# CITY OF ALBUQUERQUE

June 20, 2017

RE: **Lot 31 Block 6 Unit 18, S.A.D. 228**  
**6543 Pato Rd. NW**  
**Grading and Drainage Plan**  
**Engineers Stamp Date 6-19-17 (D10D003M31)**

DRAINAGE PLAN

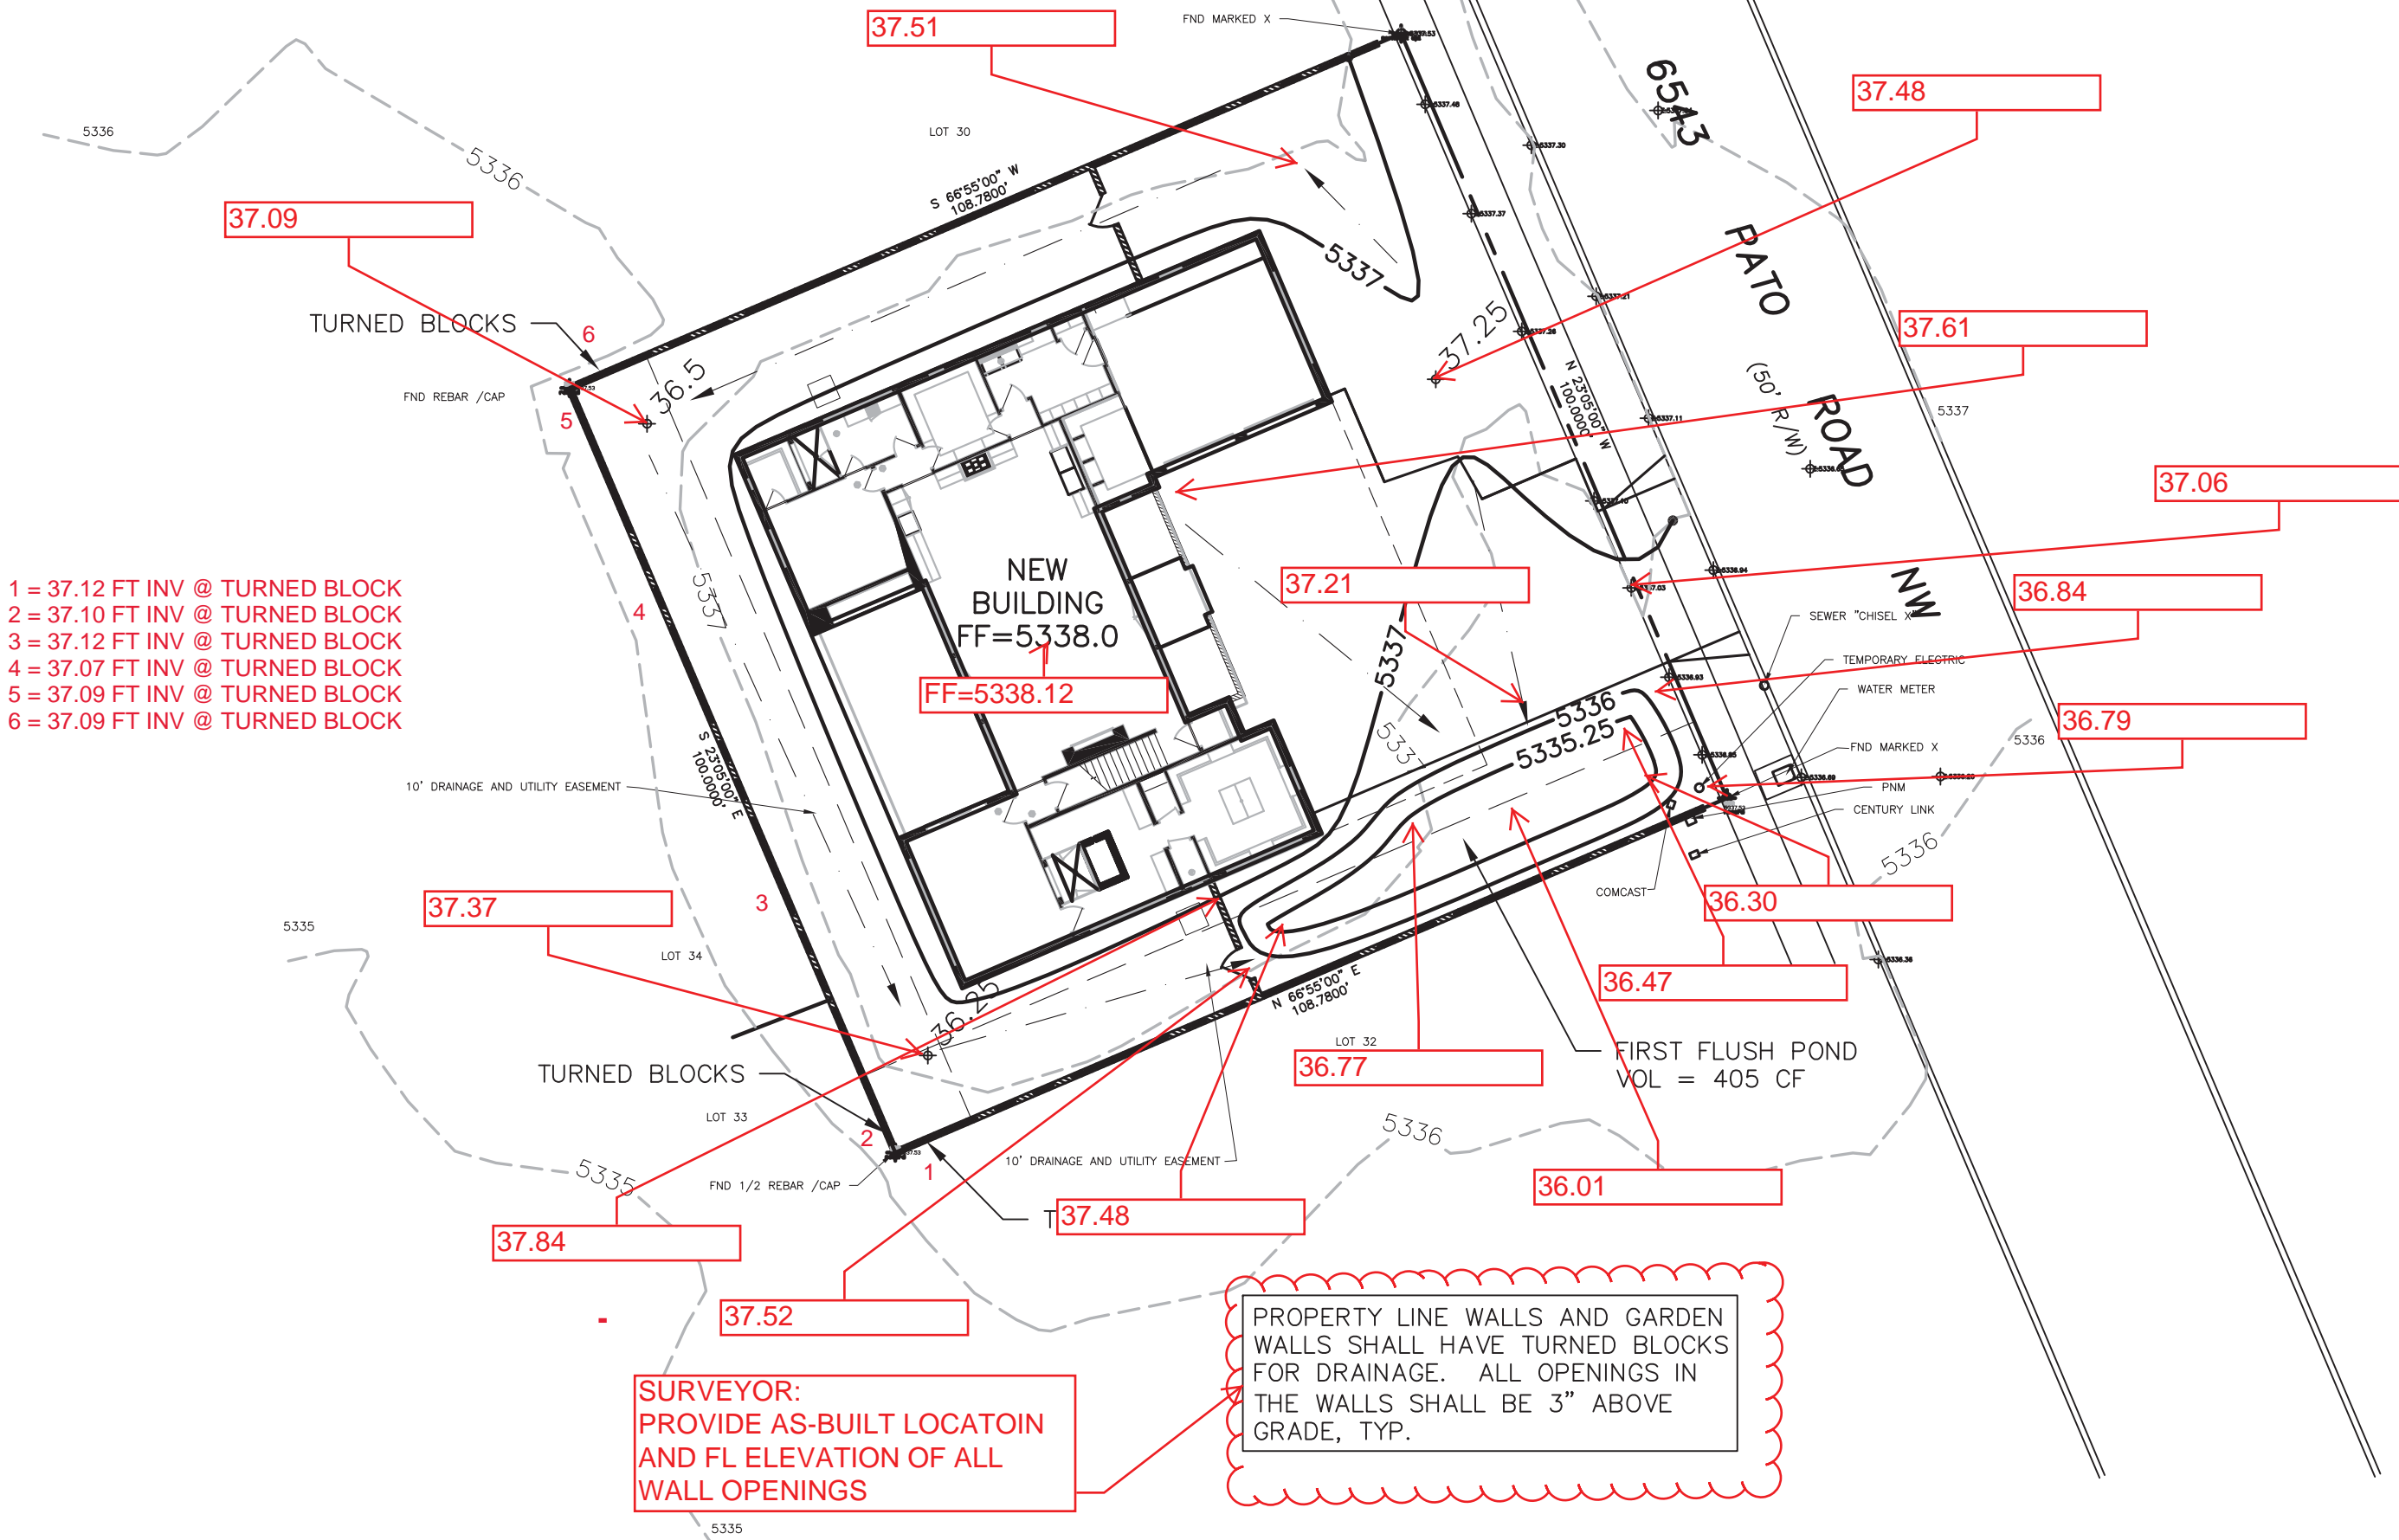
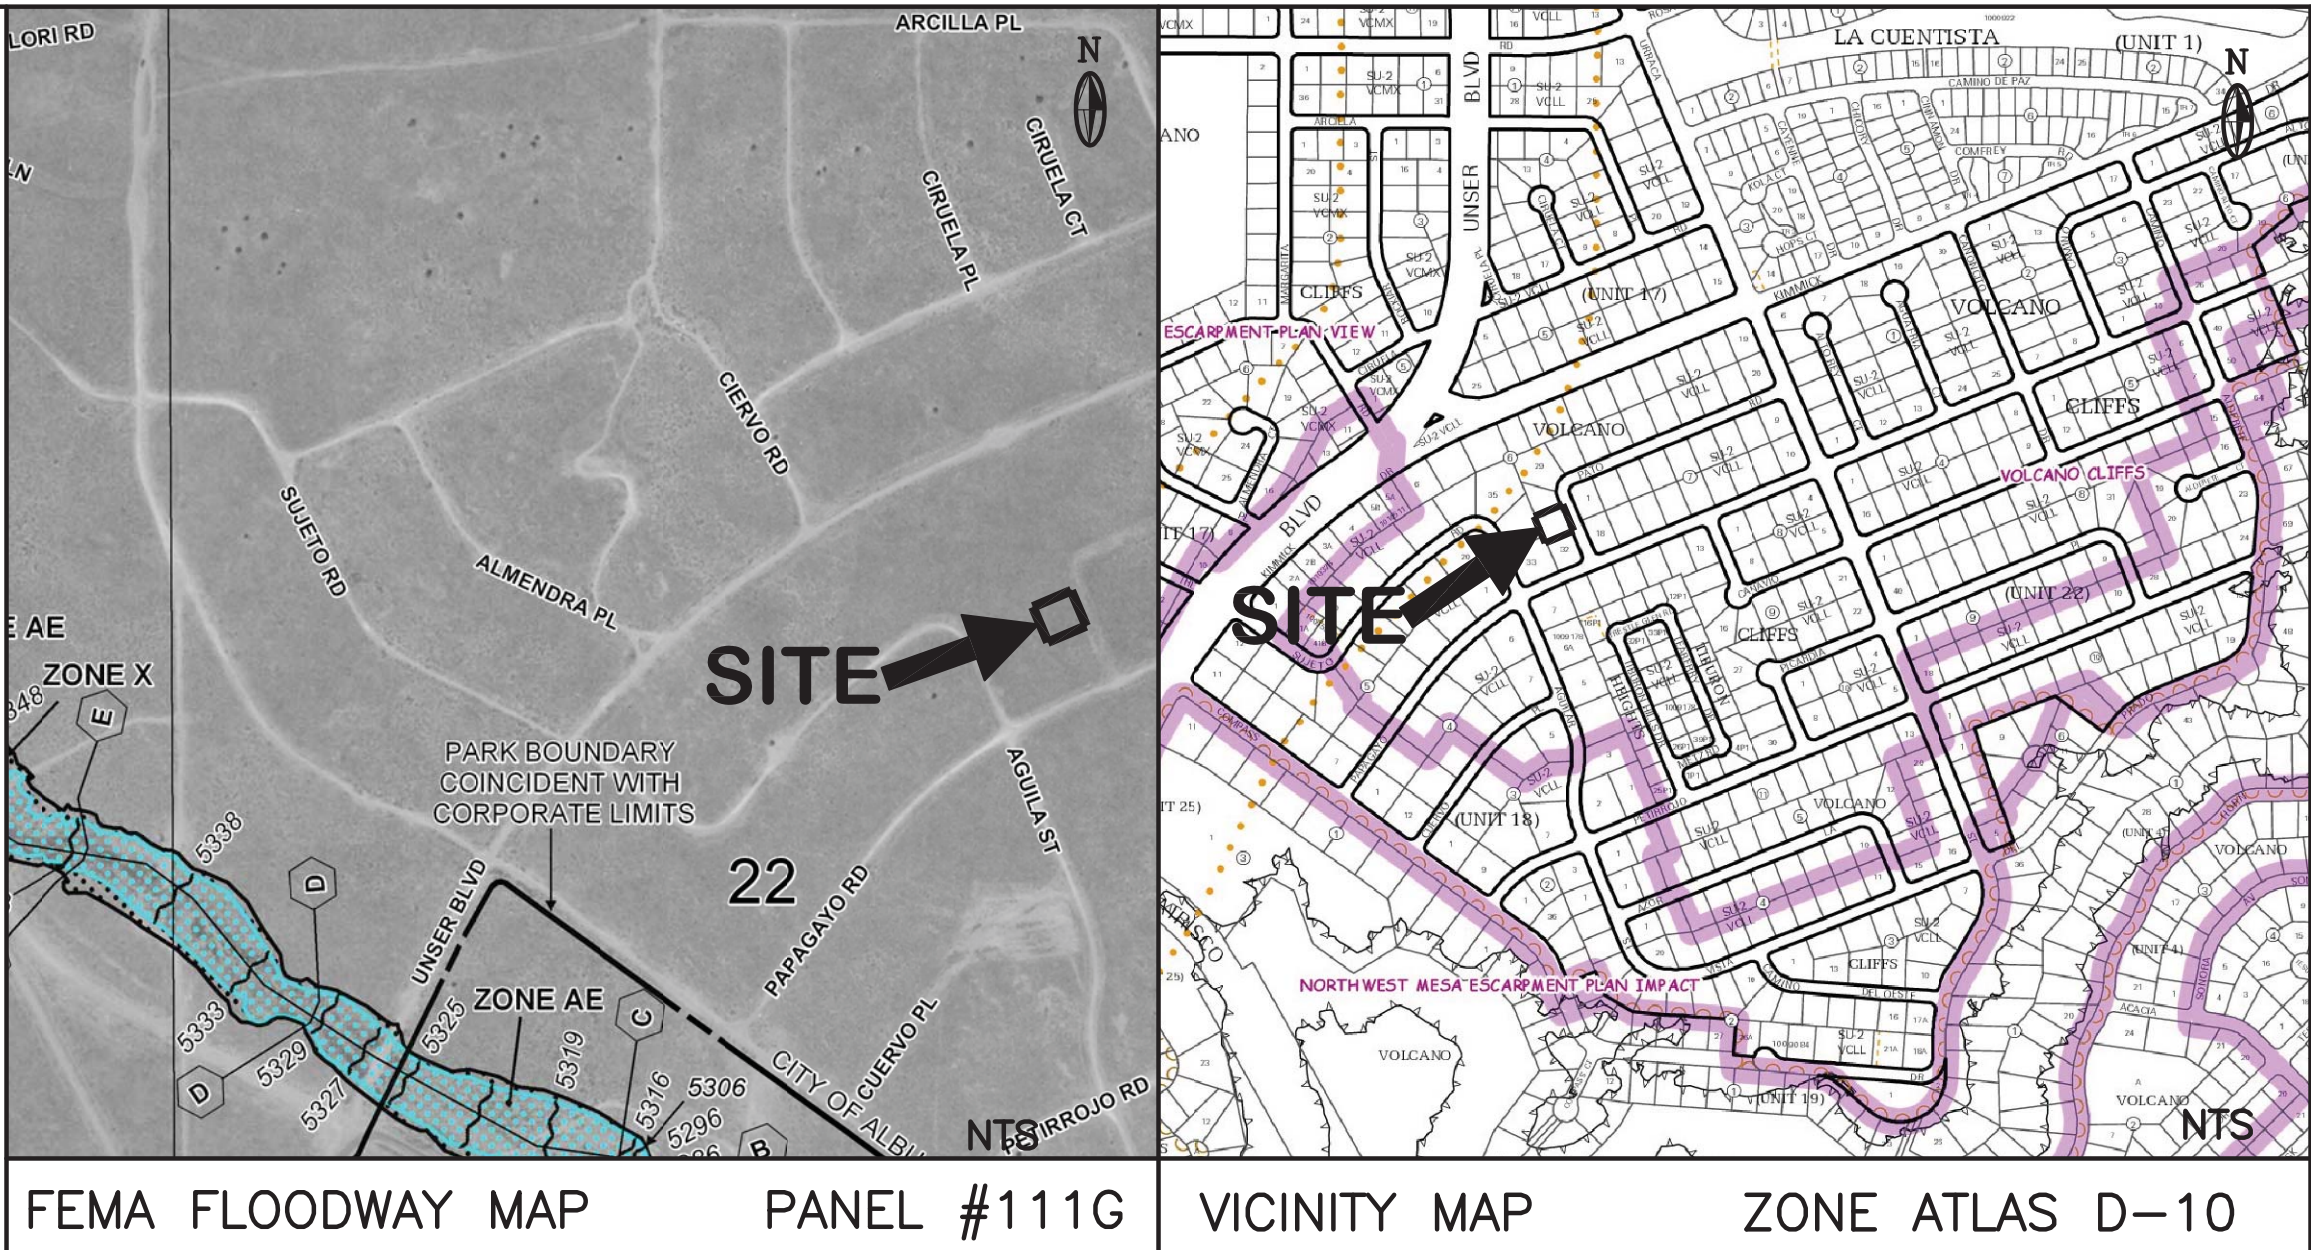
- Provide the calculations for the openings in the North and South rear yard walls for flows heading North to South, as well as the southwest corner rear yard wall for flows heading from east to west.
